Your Ref: EN010087  
Date: 27 April 2020

My Ref: 18/01/0091  
Tel No.: 01603 223231  
Email: john.r.shaw@norfolk.gov.uk

**Application by Norfolk Boreas Limited for the Norfolk Boreas Offshore Windfarm.  
Response to the Examining Authority's third round of written questions and  
requests for information (ExQ3) Issued on 23 March 2020, together with comments  
upon submissions at Deadlines 7 and 8.**

CAWSTON HIGH STREET - INTERVENTION SCHEME  
Scale 1:500

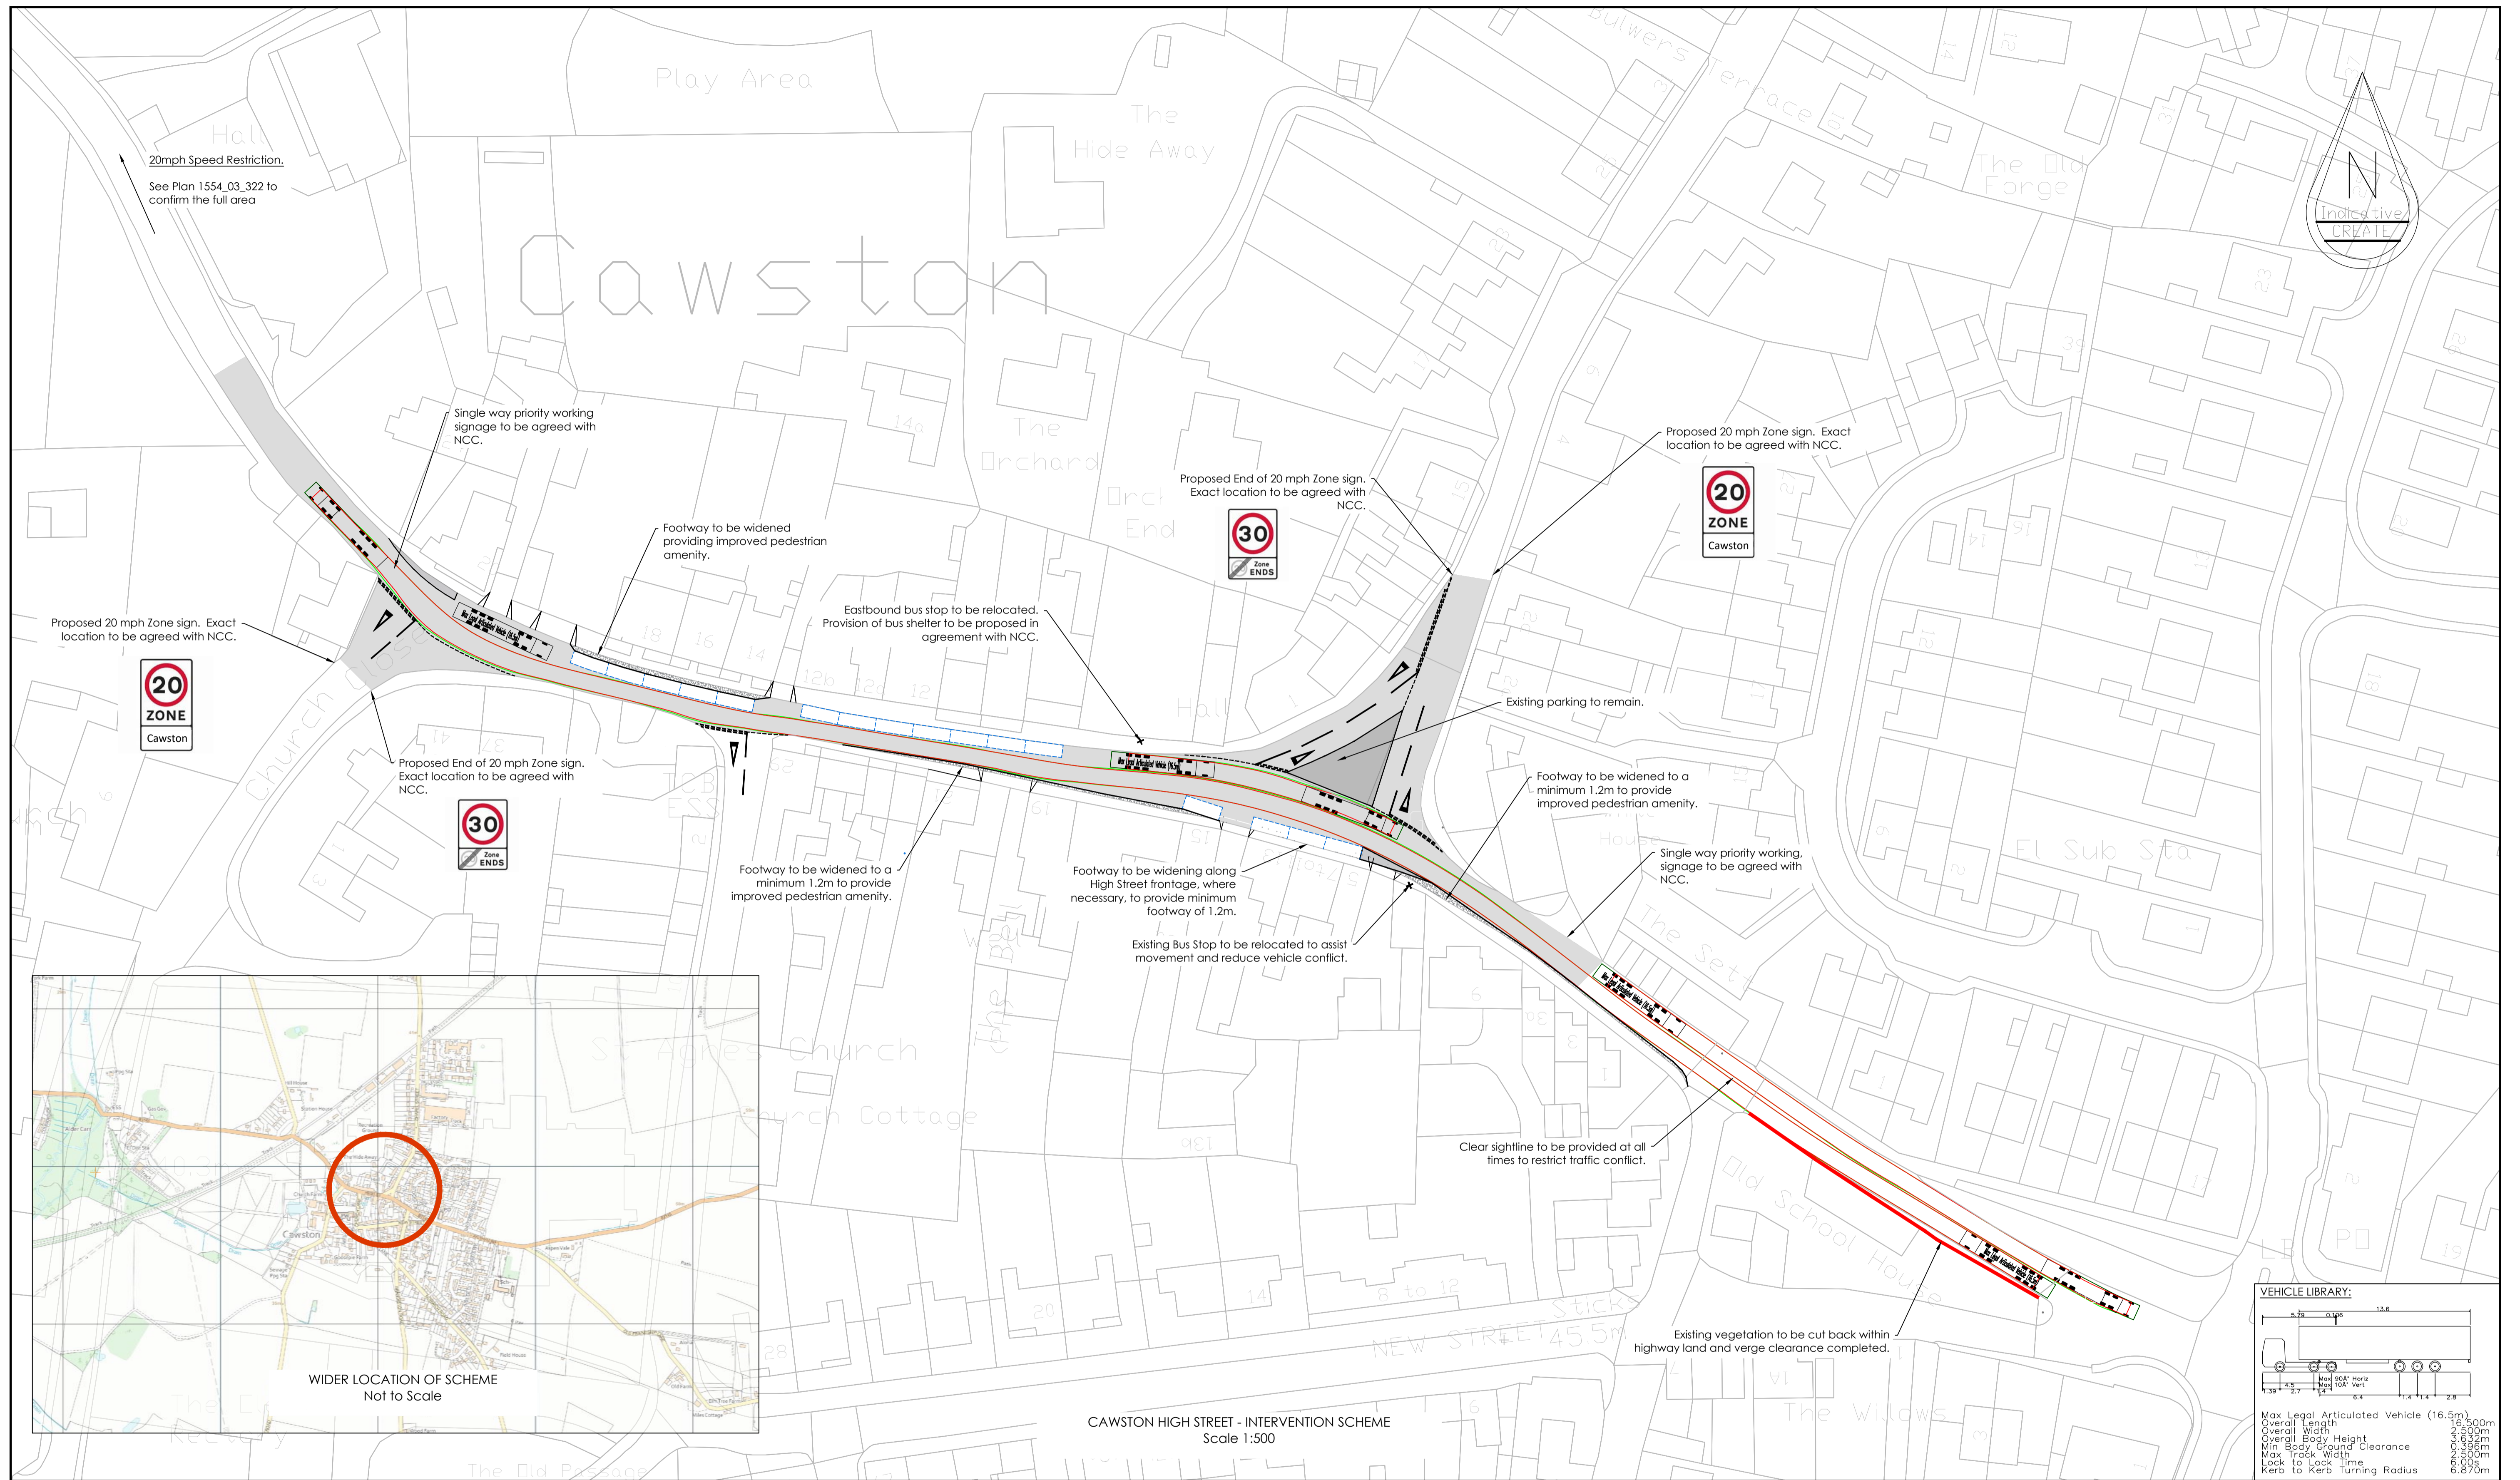
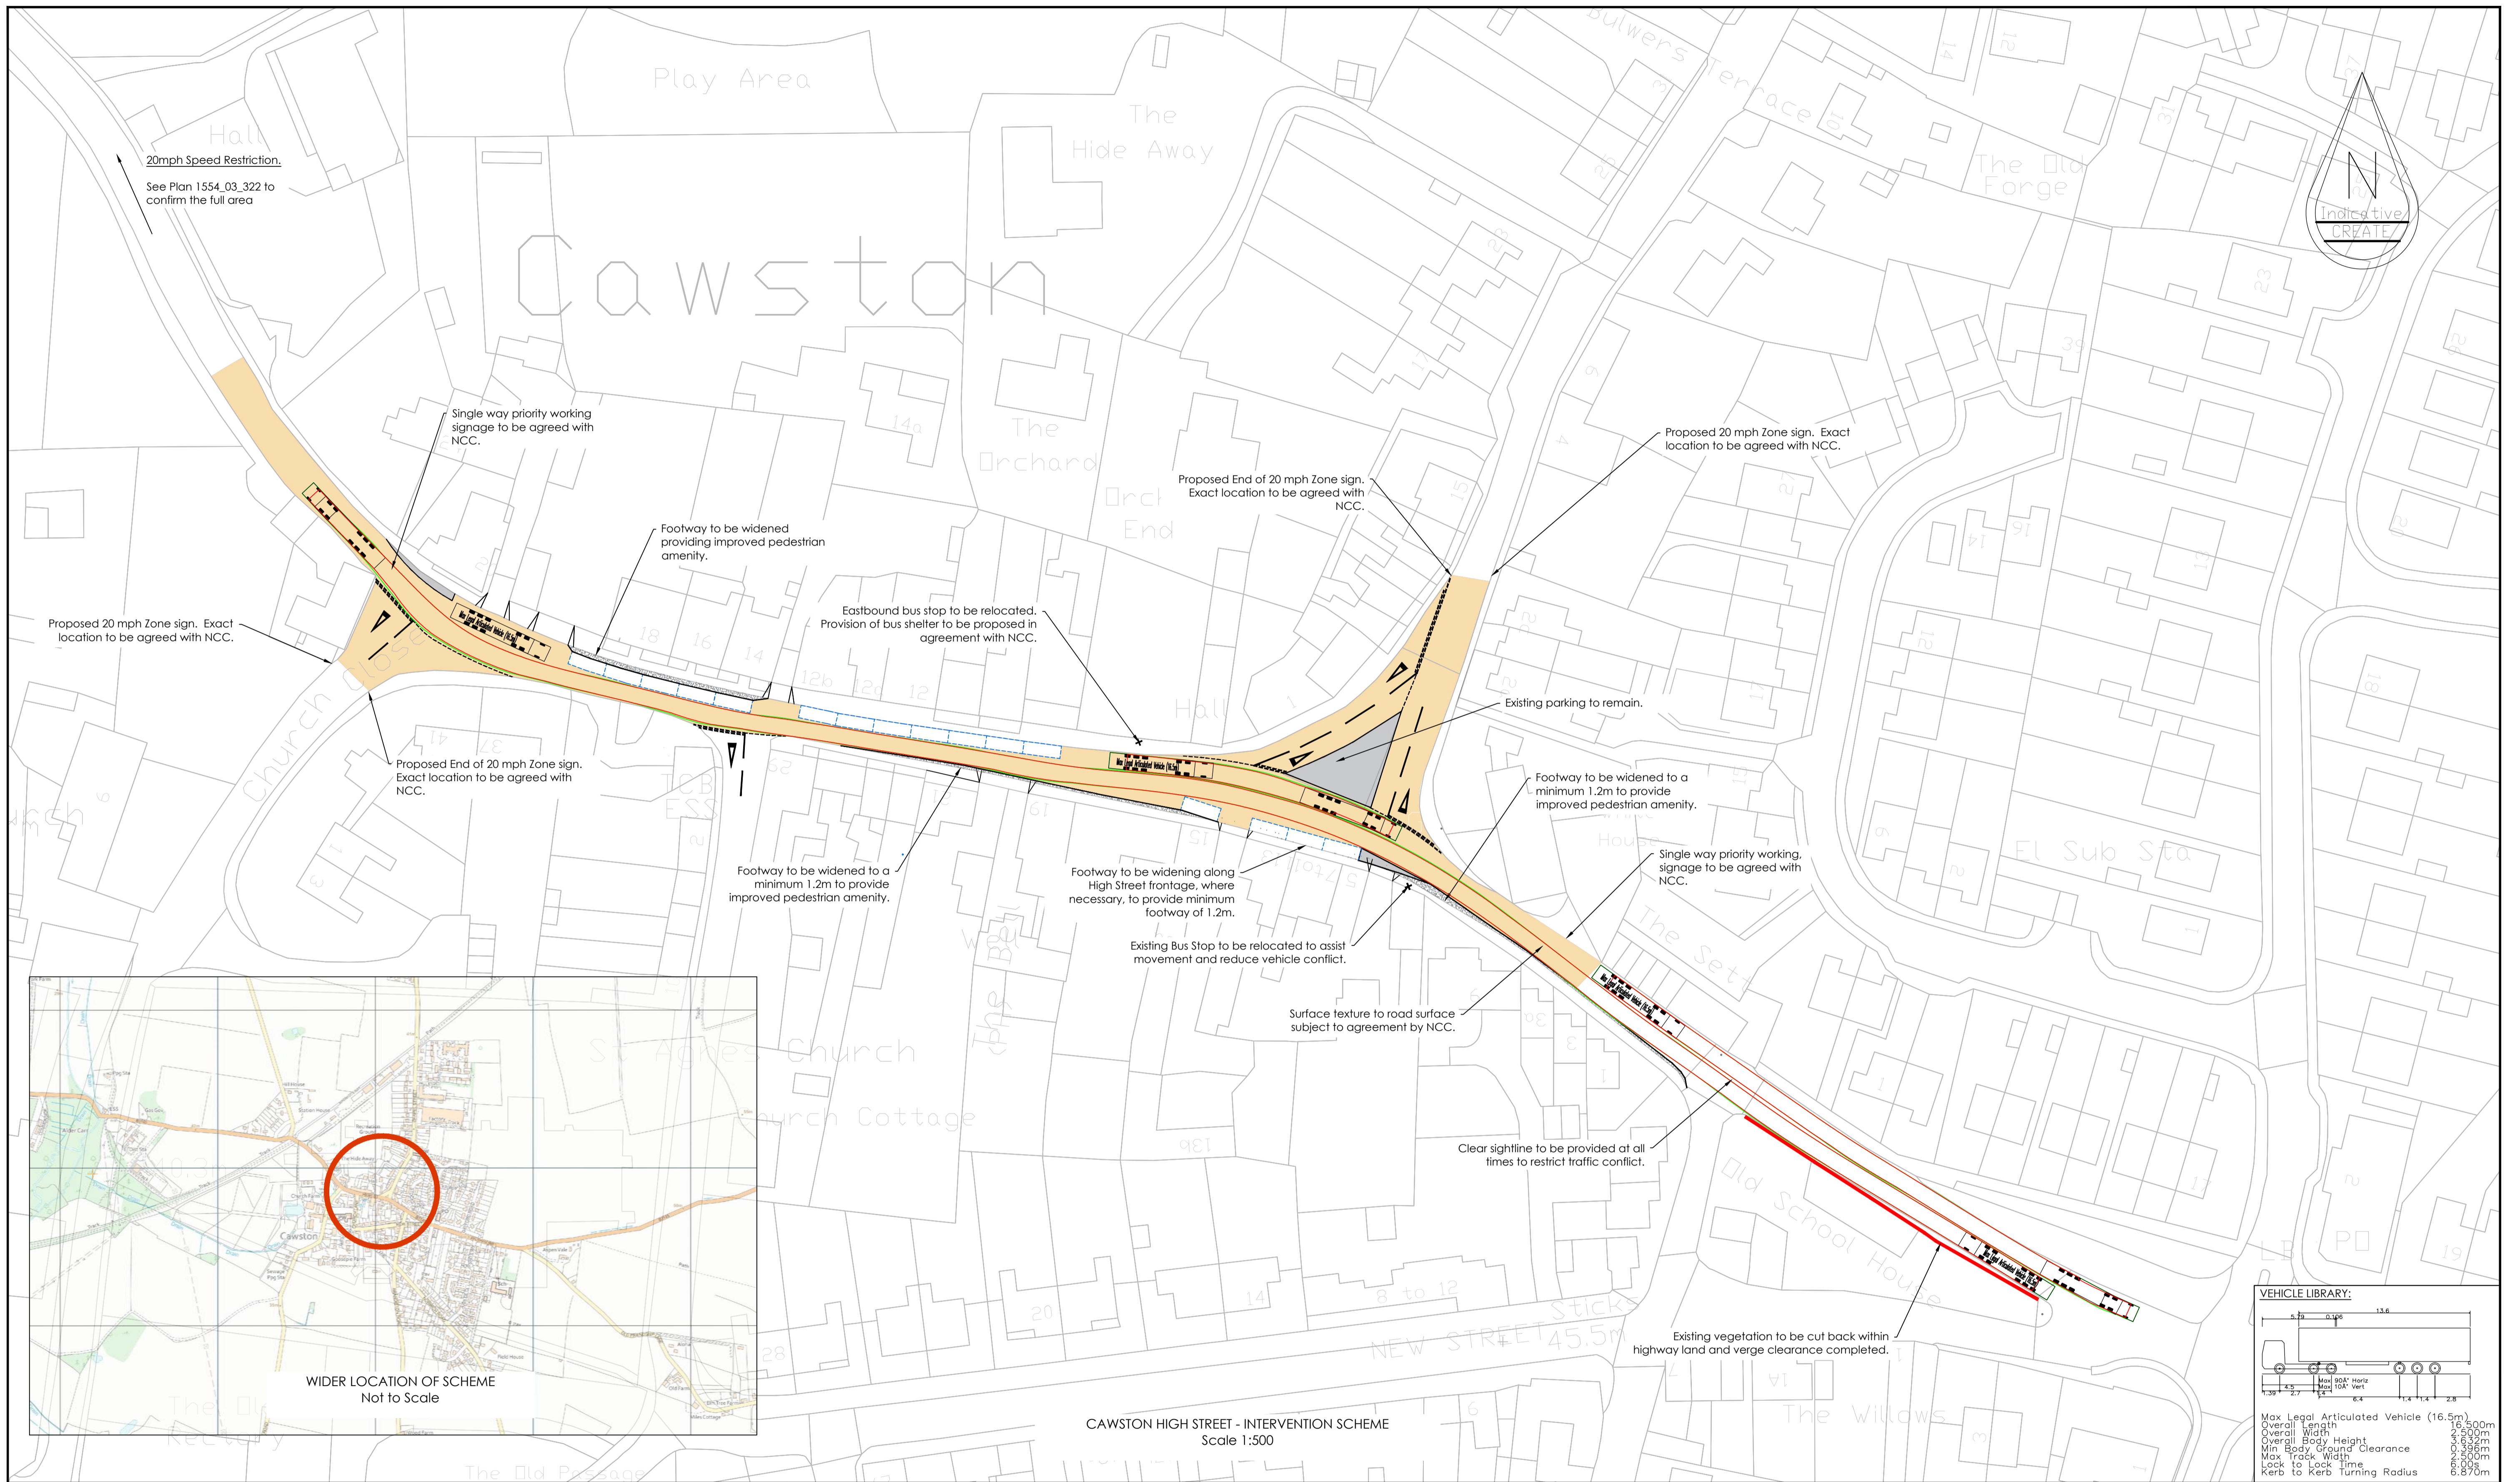
Whilst we have no objection to the Applicants highway intervention scheme (Option 1), nevertheless we have identified a driver compliance issue. This was also identified within the Applicants Road Safety Audit which recommended a review of "...the compliance of drivers following the introduction of the reduced speed limits and introduce further measures if necessary"

If parking occurs outside the designated parking areas; traffic fails to yield at the correct points; or if traffic speeds are much higher than 20mph, the proposed intervention scheme could fail.

Whilst not objecting to the Applicants highway intervention scheme (Option 1), nevertheless we have identified a driver compliance issue and we have advised the Applicants they need to look at solutions in advance. We believe there are two possible options – either

- (i) reduce the volume of HGV traffic passing through Cawston down from the capped 239 HGV movements per day (which would lengthen the duration of the project).

- (ii) Introduce a one-way system with HGV's entering the village but exiting via Option 5. As indicated above, we do not support this as it has several significant safety problems and also the fabric of the road is not sufficient to cater for that volume of traffic.
